OEH Science Division

Review of Springvale and Angus Place Mine Extension EISs

Figure 4 Angus Place / Springvale – Structure Zones (Palaris 2012)

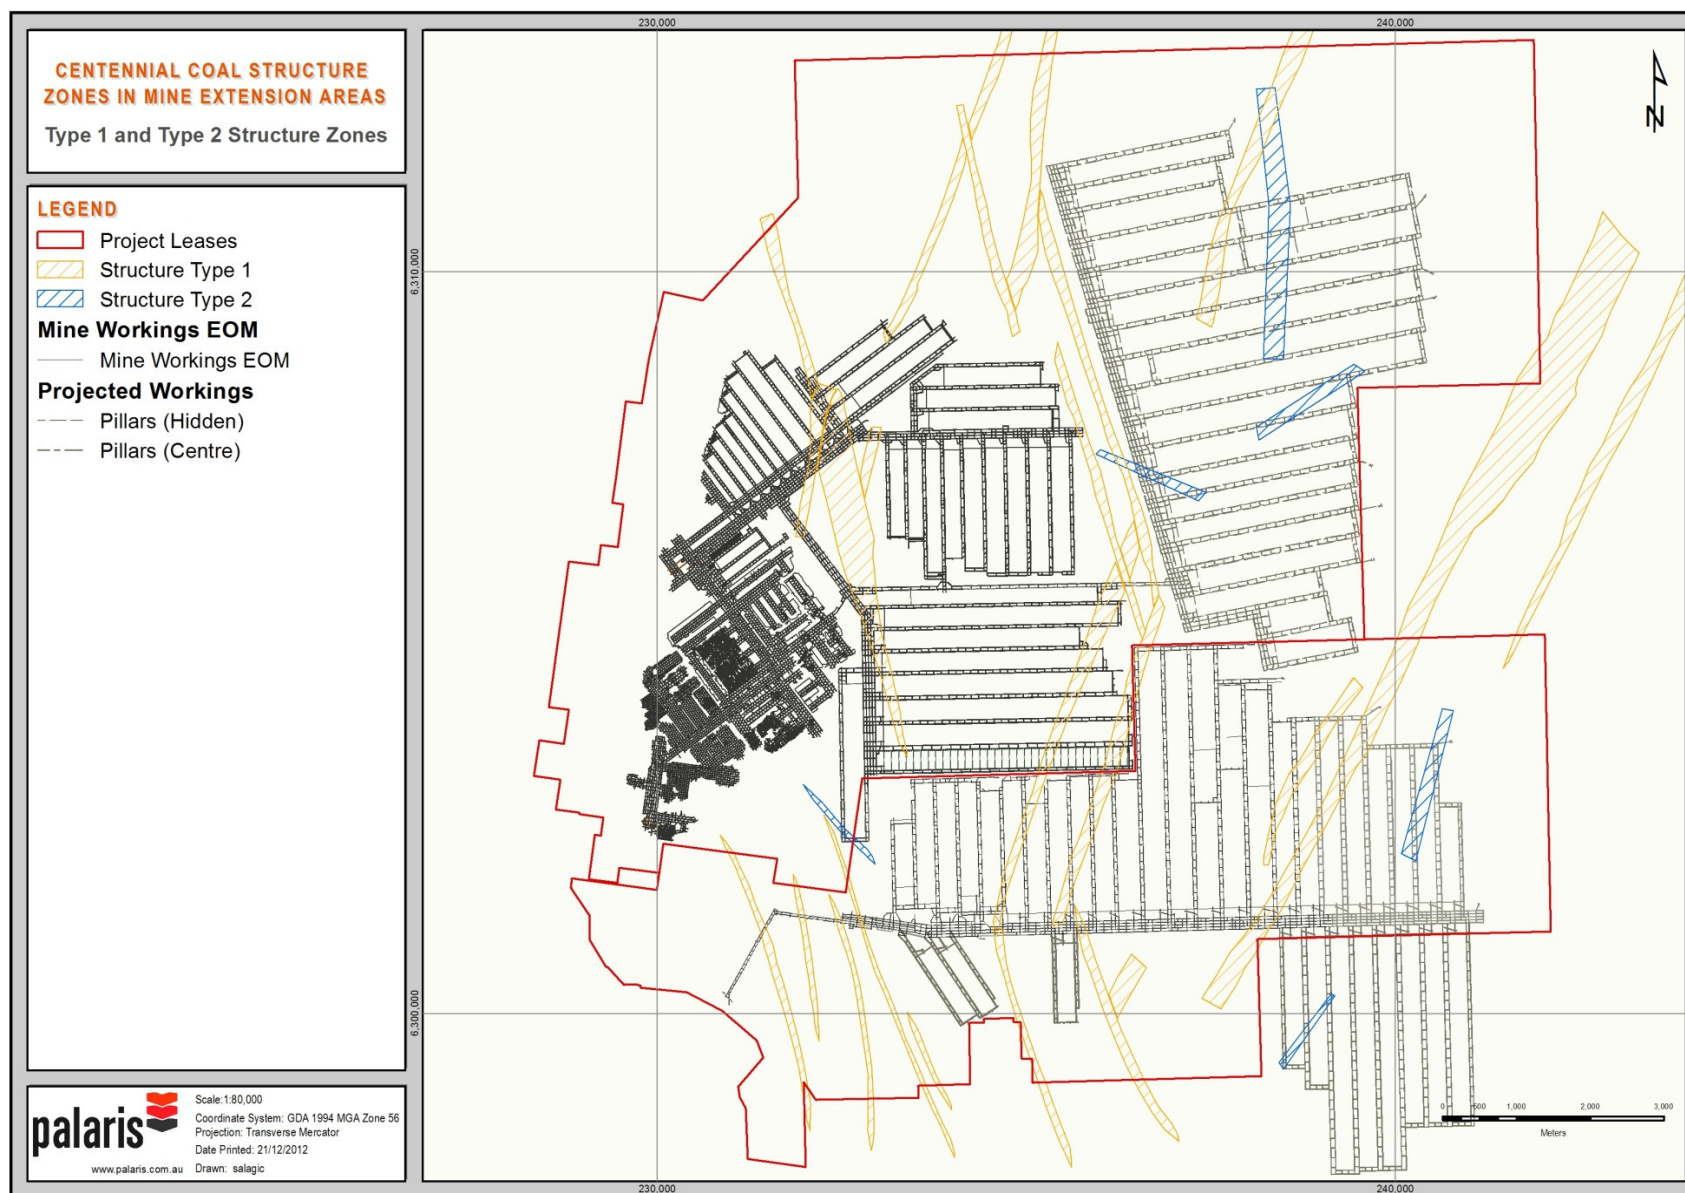
The NPSS are clearly at risk of bedrock fracturing from the proposed mine plan. The presence of Type 1 & 2 lineaments directly under a number of NPSS EECs clearly increases the potential for such impacts to occur. As identified earlier, the NPSS EECs have high scientific and community value (swamps above the mine expansion potentially have a community value of at least \$157M). Any impacts that do eventuate as a result of conventional and non-conventional subsidence are likely to be irreversible. There are no proven remediation measures capable of replacing perched aquifers within swamps once fractured and drained as a result of mining subsidence (WRL Draft 2013).

Type 1 and Type 2 geological structure zones have been identified within the Extension Area, which are shown in Drawing No. MSEC593-07. It is expected, that locally increased subsidence and compressive strains will be observed in these locations.
